Preliminary Acceptance Punchlist
El Paso County – Department of Public Works - Stormwater Section

Project Name:	Bent Grass Residential F2
EDARP Filing Number(s):	SF1914, CON2022
ESQCP Number:	ESQ228
Attendees:	DPW SW: Dylan Finley, Ben Jones DPW Development Services: Spencer Pirzadeh, Brad Walters Developer: George Hart, Erin Ganaway
Date of Walk-Thru:	09/13/2023
Walk-Thru Number:	1

G7.02
Sheet 22 of 29

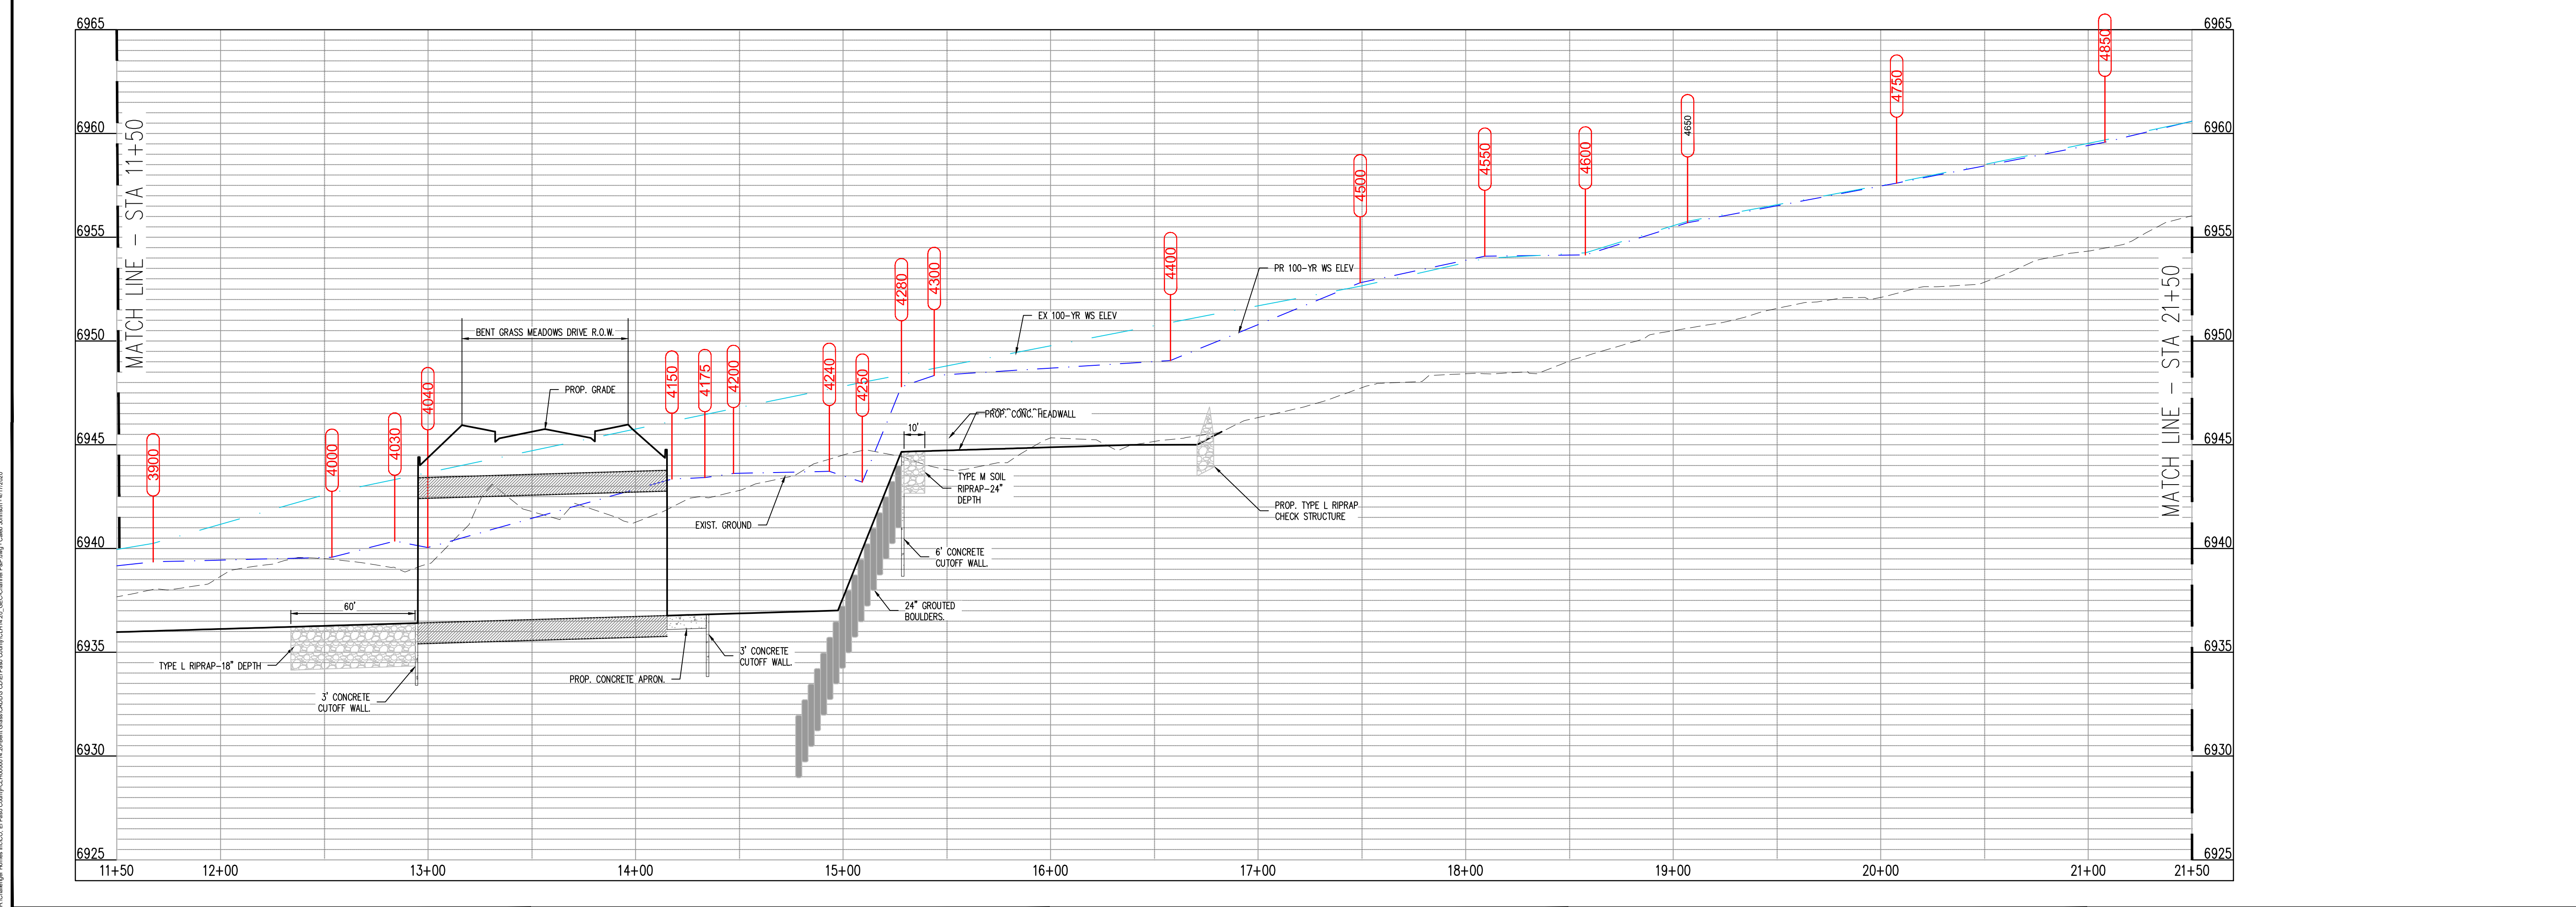
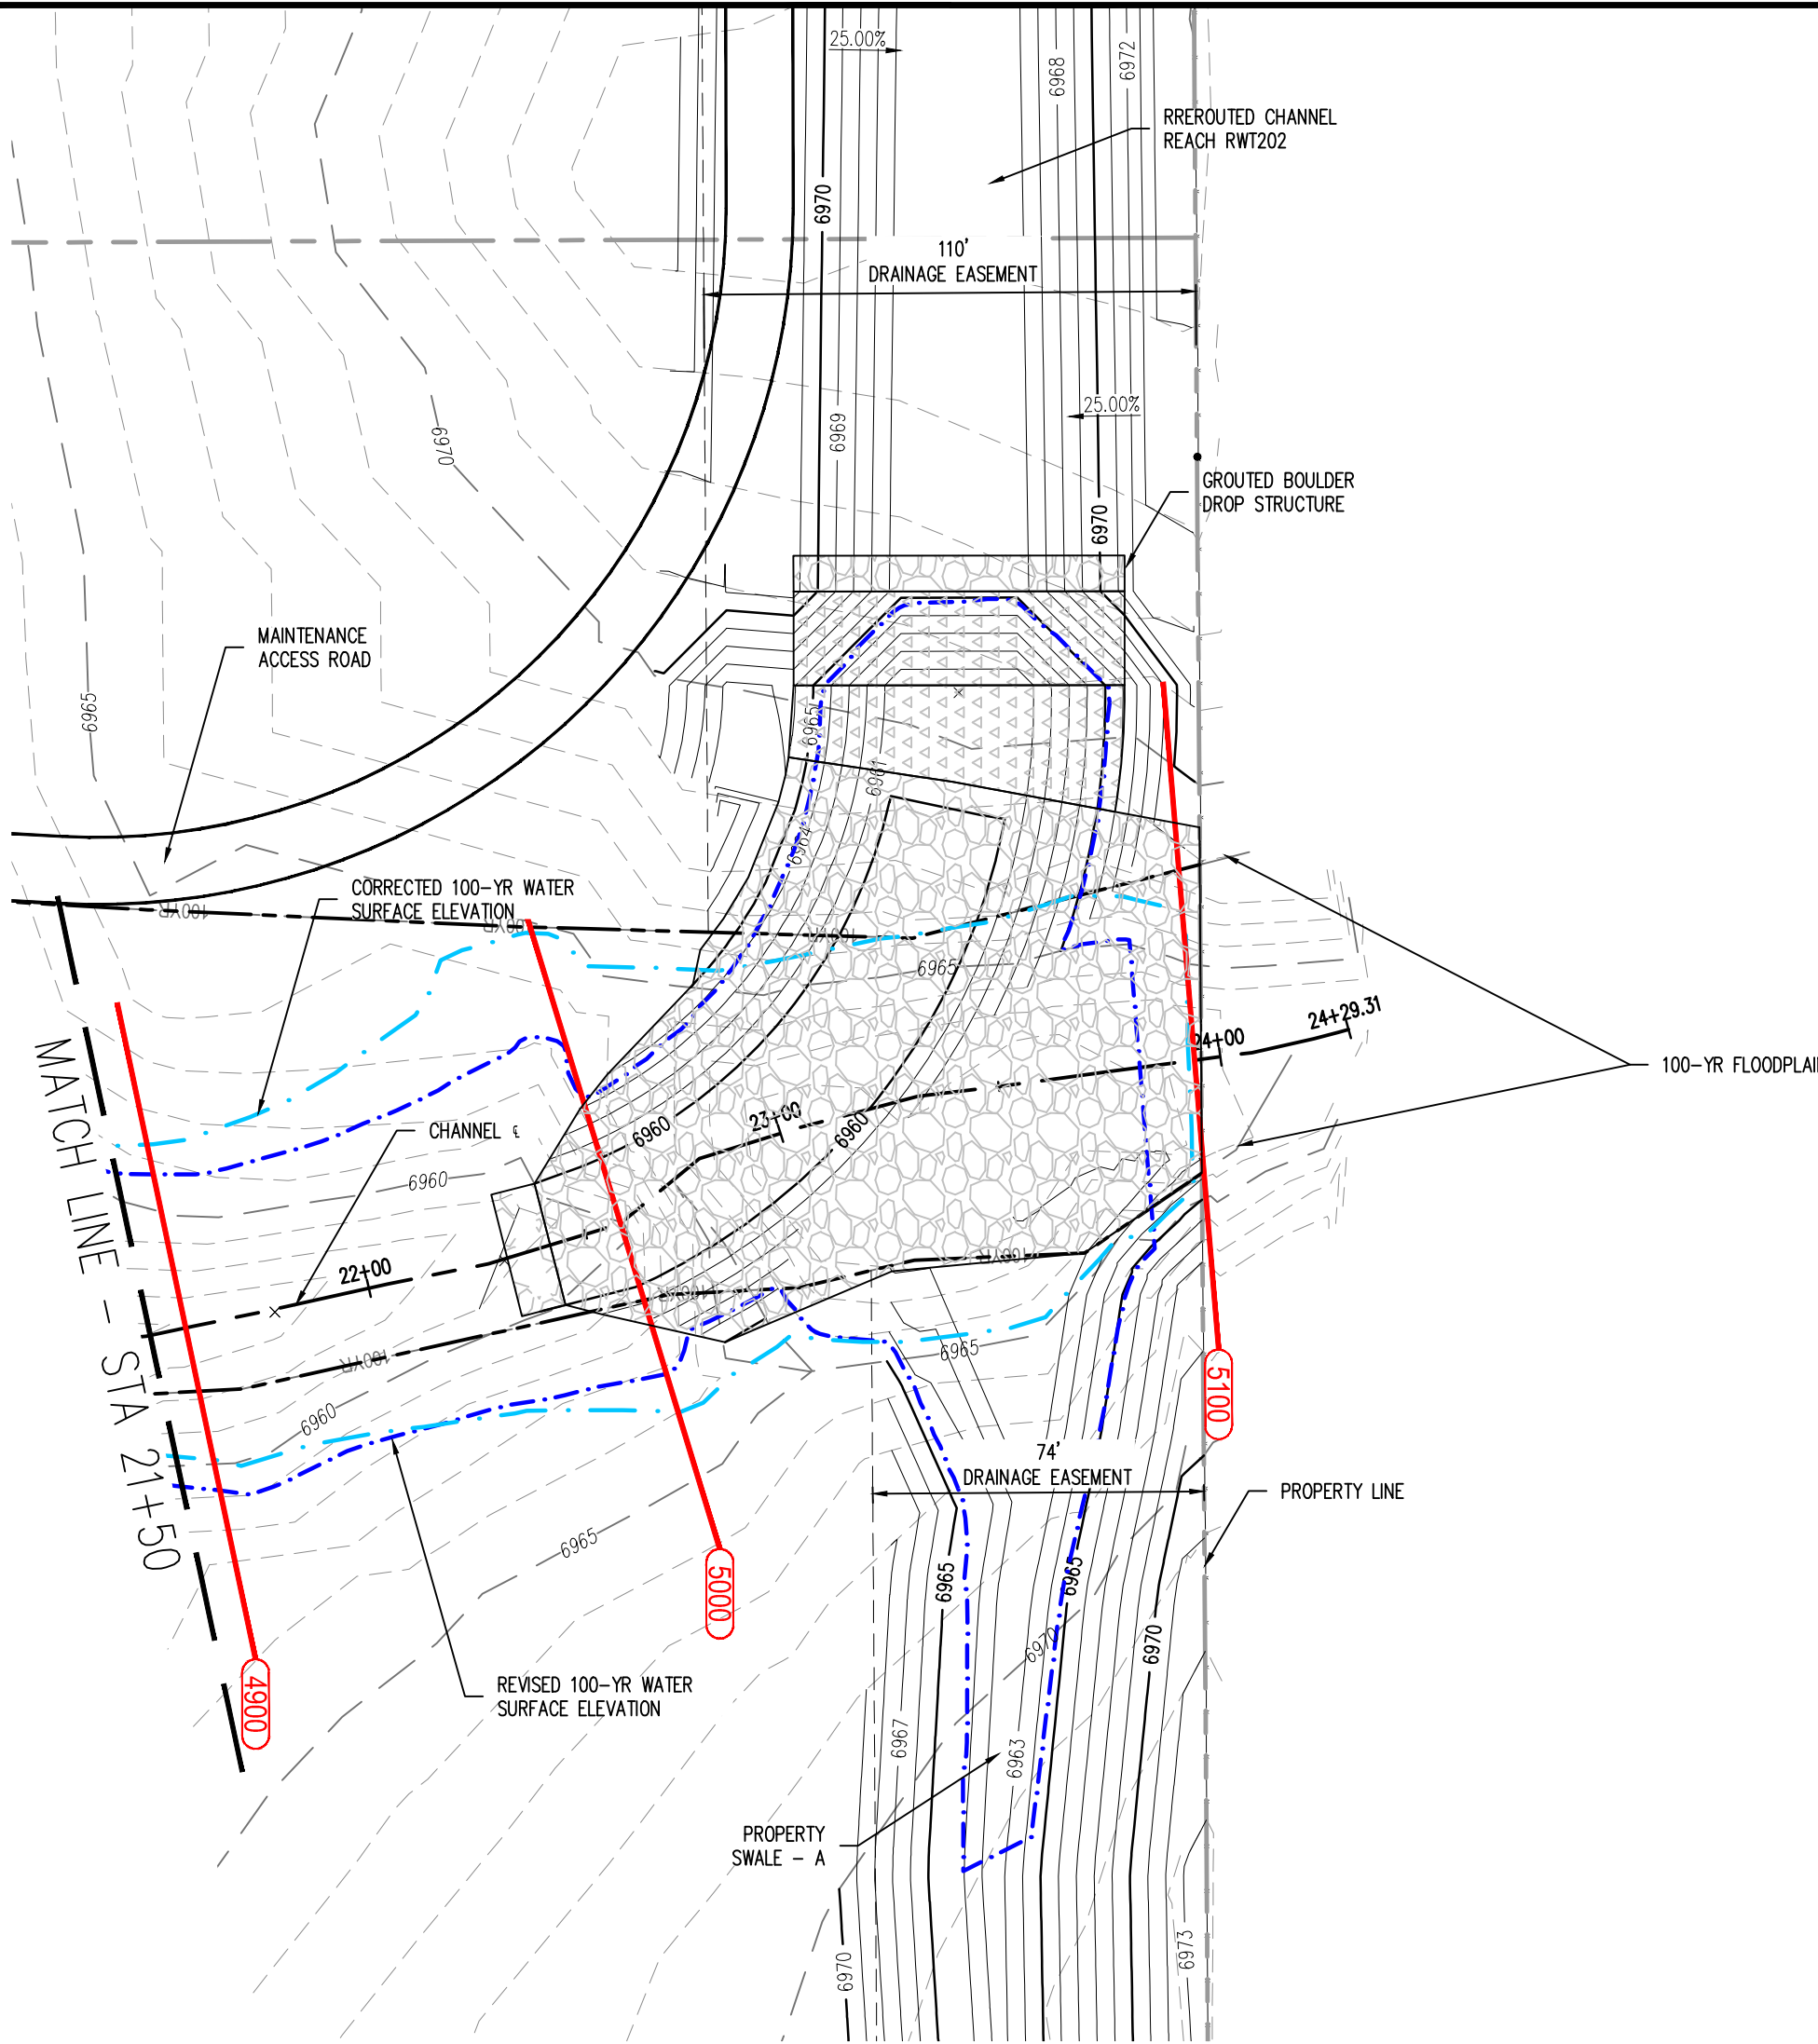
- Install drop structure in main channel with 24” grouted boulders. (West of Swale B).
- Also missing:
 - 1.5’ high riprap check dam
 - Type M Soil Riprap 24” deep
 - Six-foot deep cutoff wall
 - Three-foot deep cutoff wall
 - Type L riprap 18” deep.
